# WOODMOOR WATER & SANITATION DISTRICT NO. 1

## HWY 105 UTILITY RELOCATION - PHASE B

### GRADING AND EROSION CONTROL PLAN

NOVEMBER 2024

SHEET NO.  
**CE1.0**

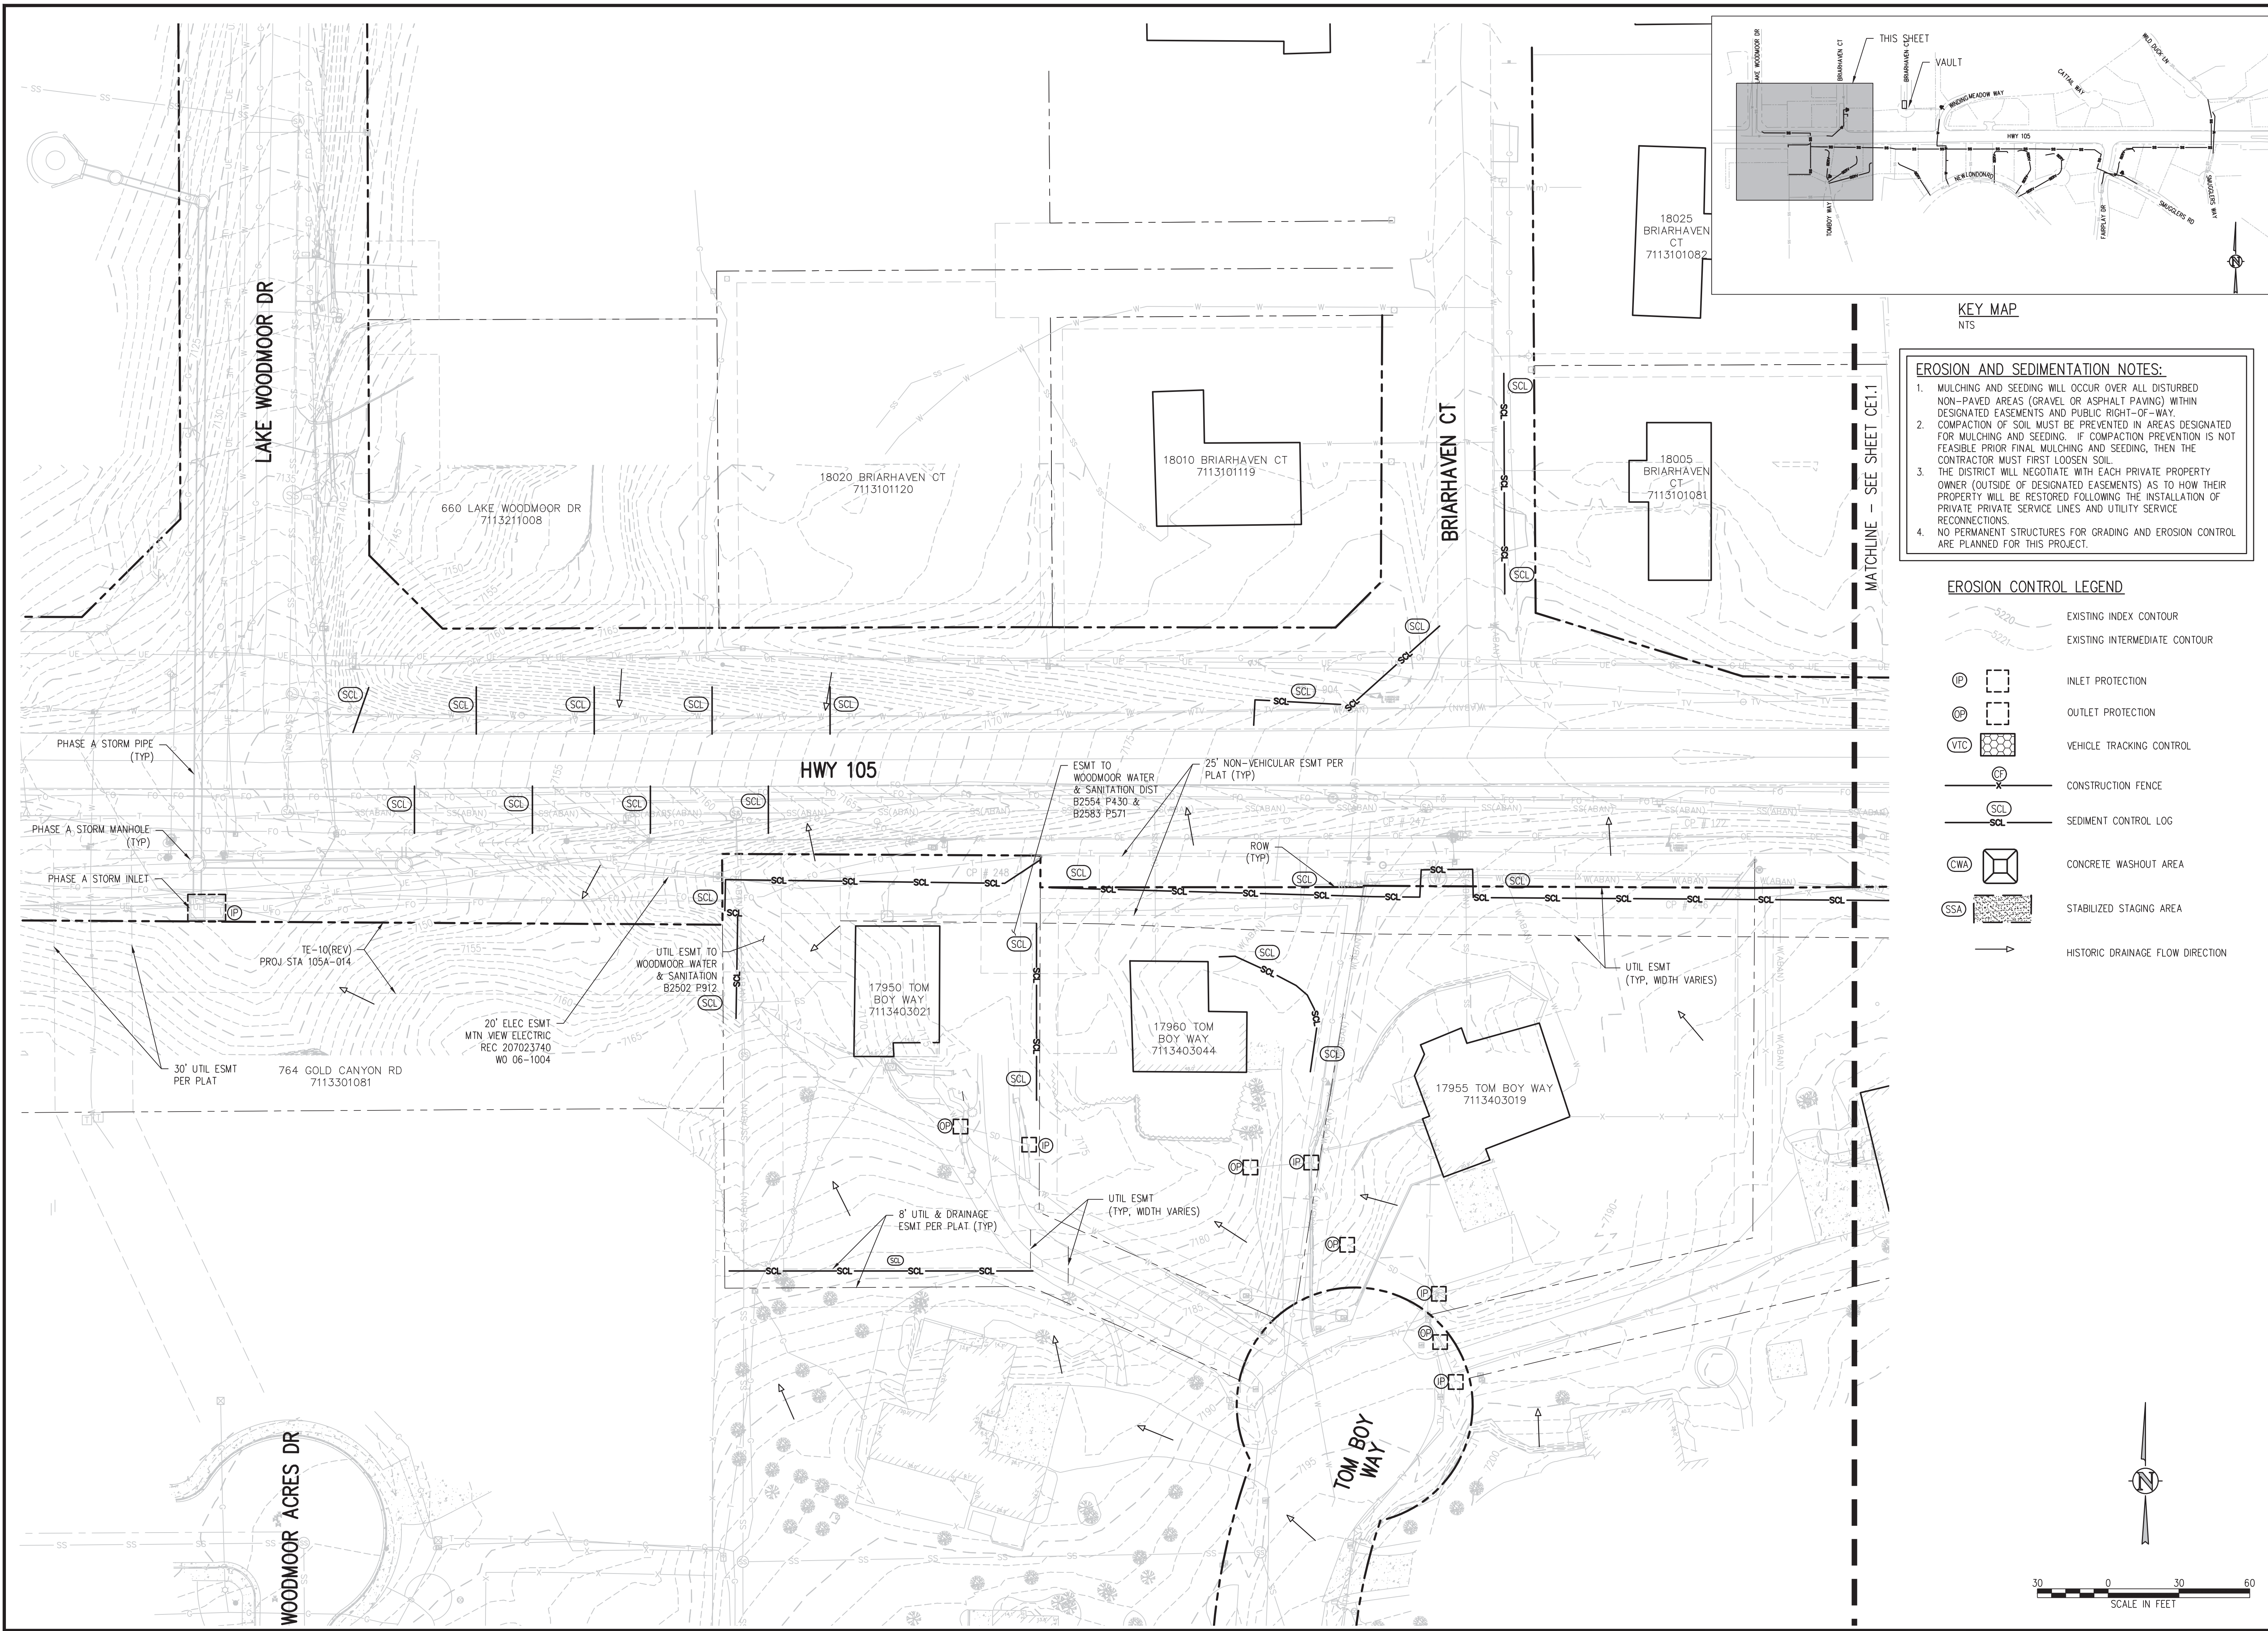
Initial BMPs must be installed prior to NTP. Recommend changing SCL to an interim BMP. All other proposed Initial BMPs should remain.  
 Show Limits of Disturbance and Limits of Constructions on Initial Sheets

To comply with the SWMP Checklist Item 17f, please add a note stating no batch plants will be utilized onsite.

SHEET NO.  
**CE1.2**

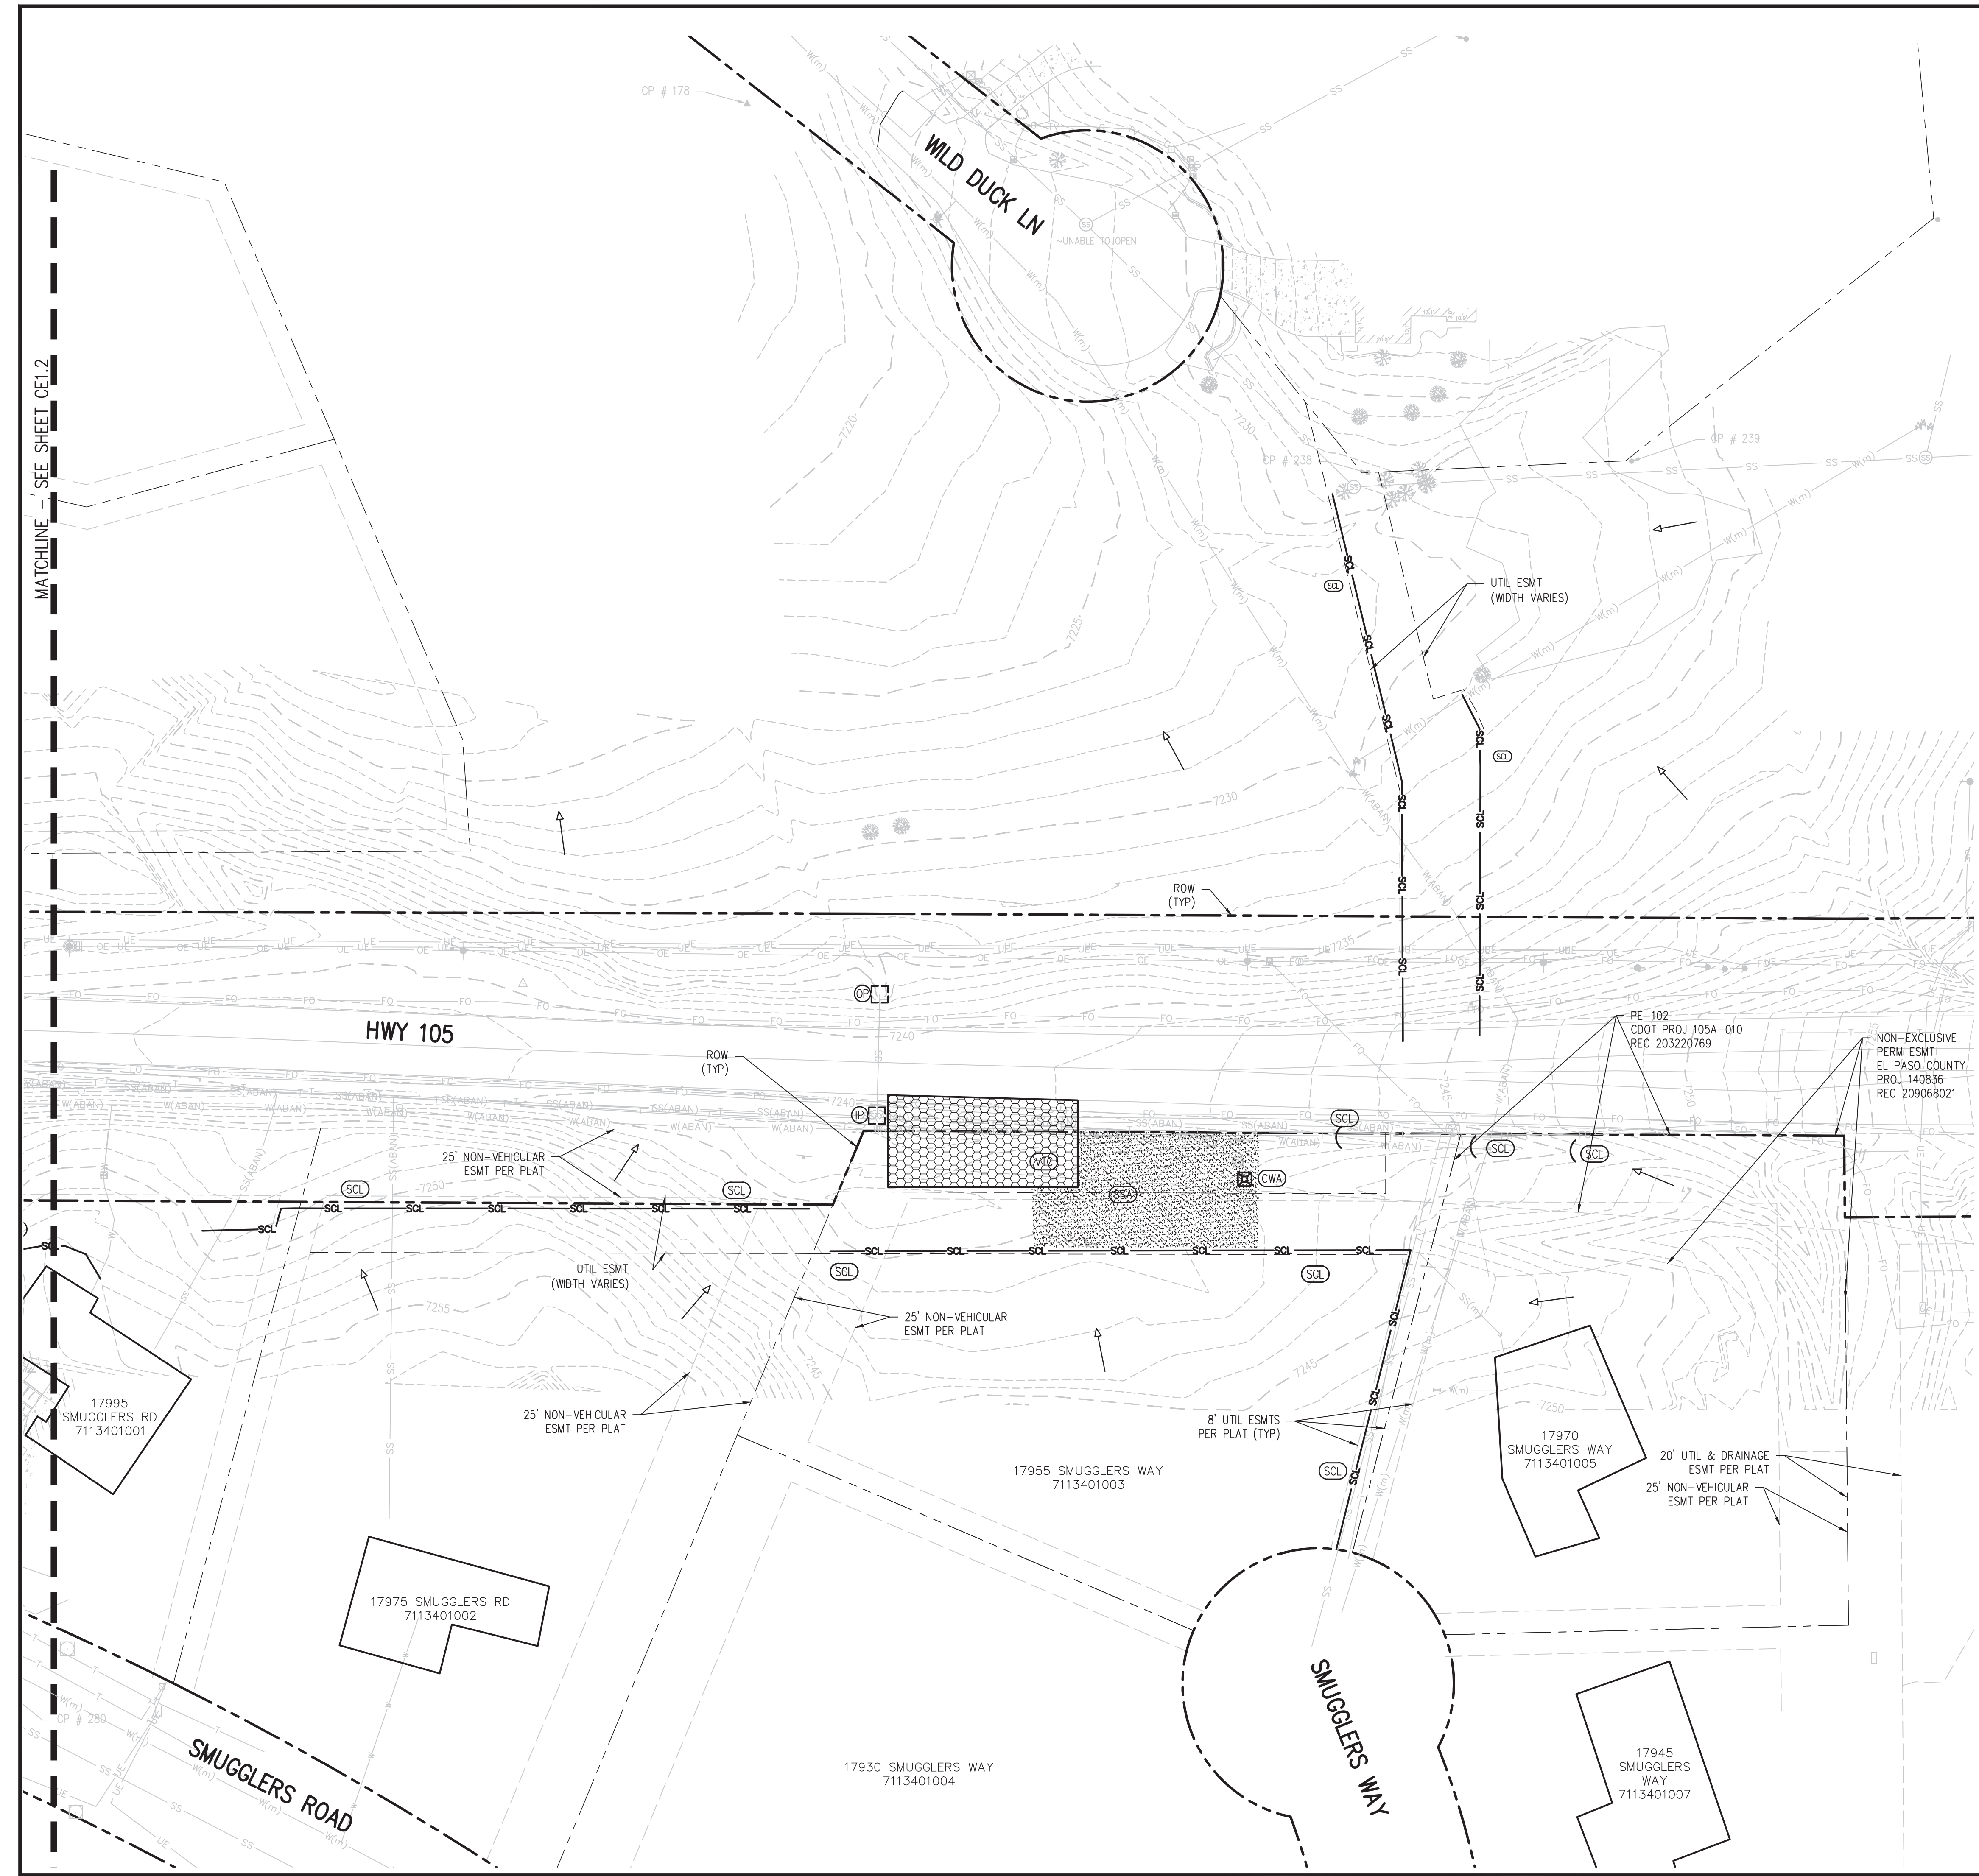
include ownership information

SHEET NO.  
CE1.3

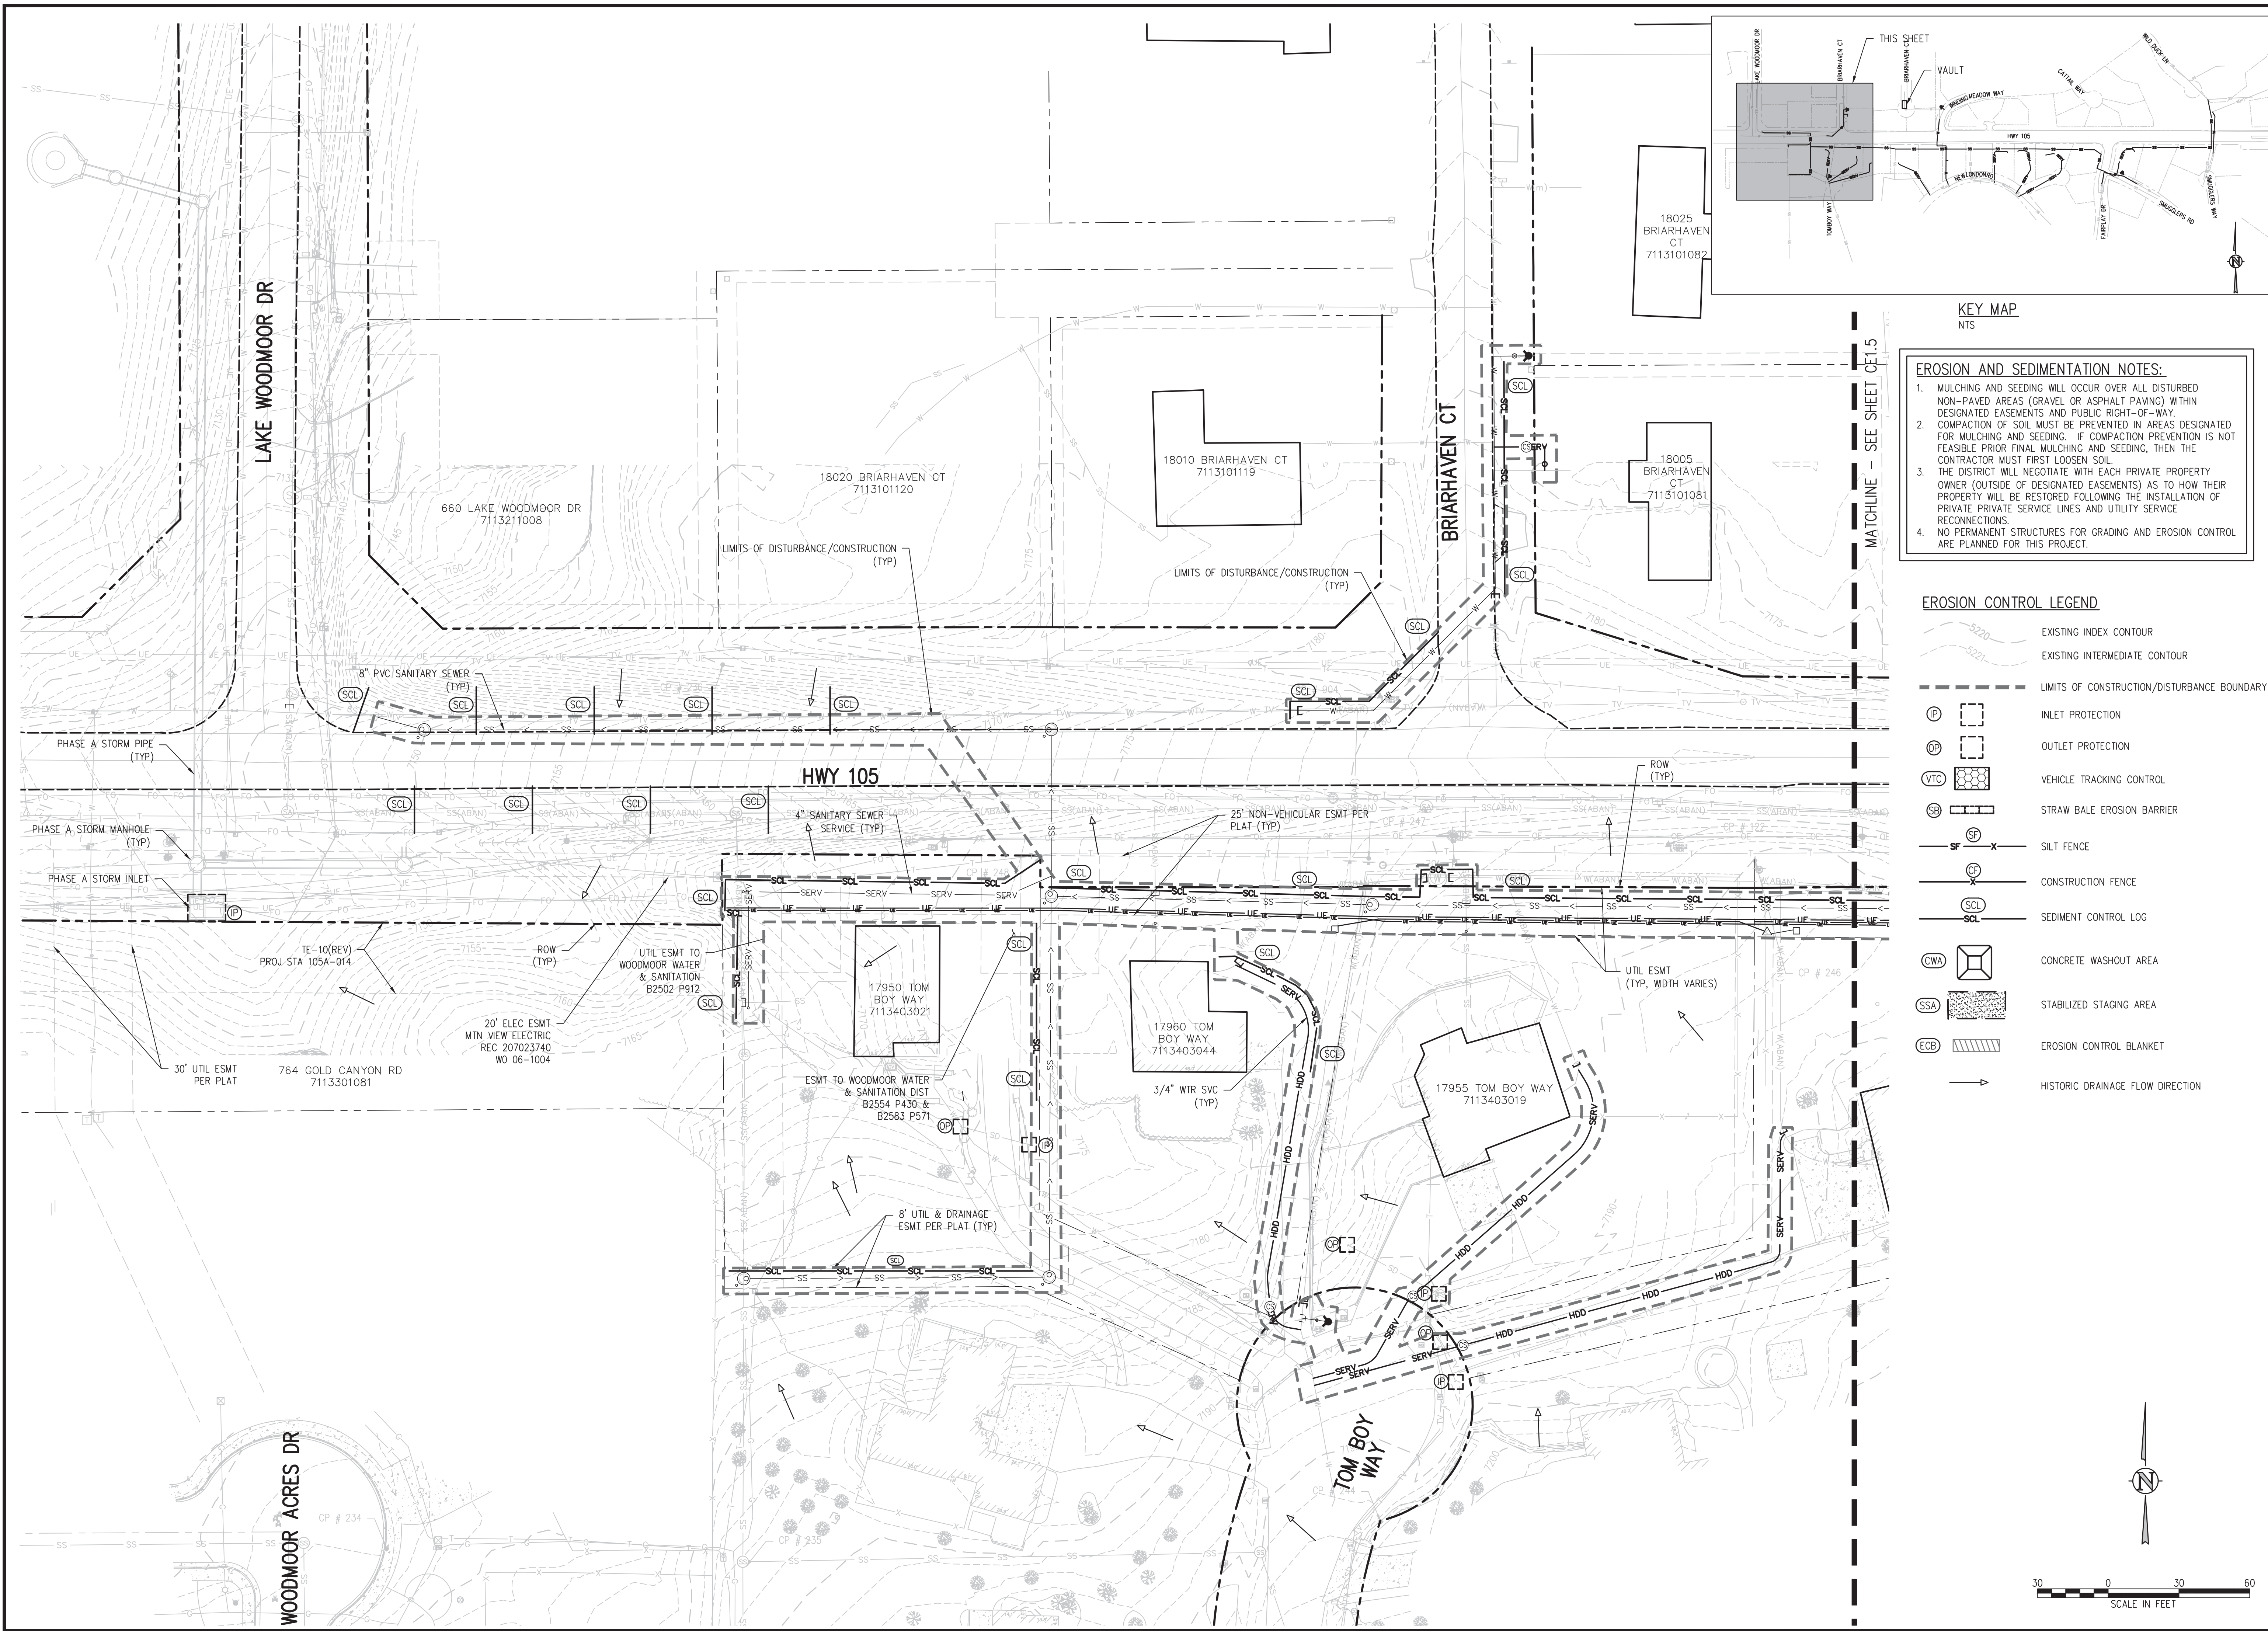
recommend earthen berm on the upstream side of trench (instead of SCL on the downstream side) that runs parallel to contours as a cost effective BMP (typ.)

SCLs should run parallel with contours (typ.)
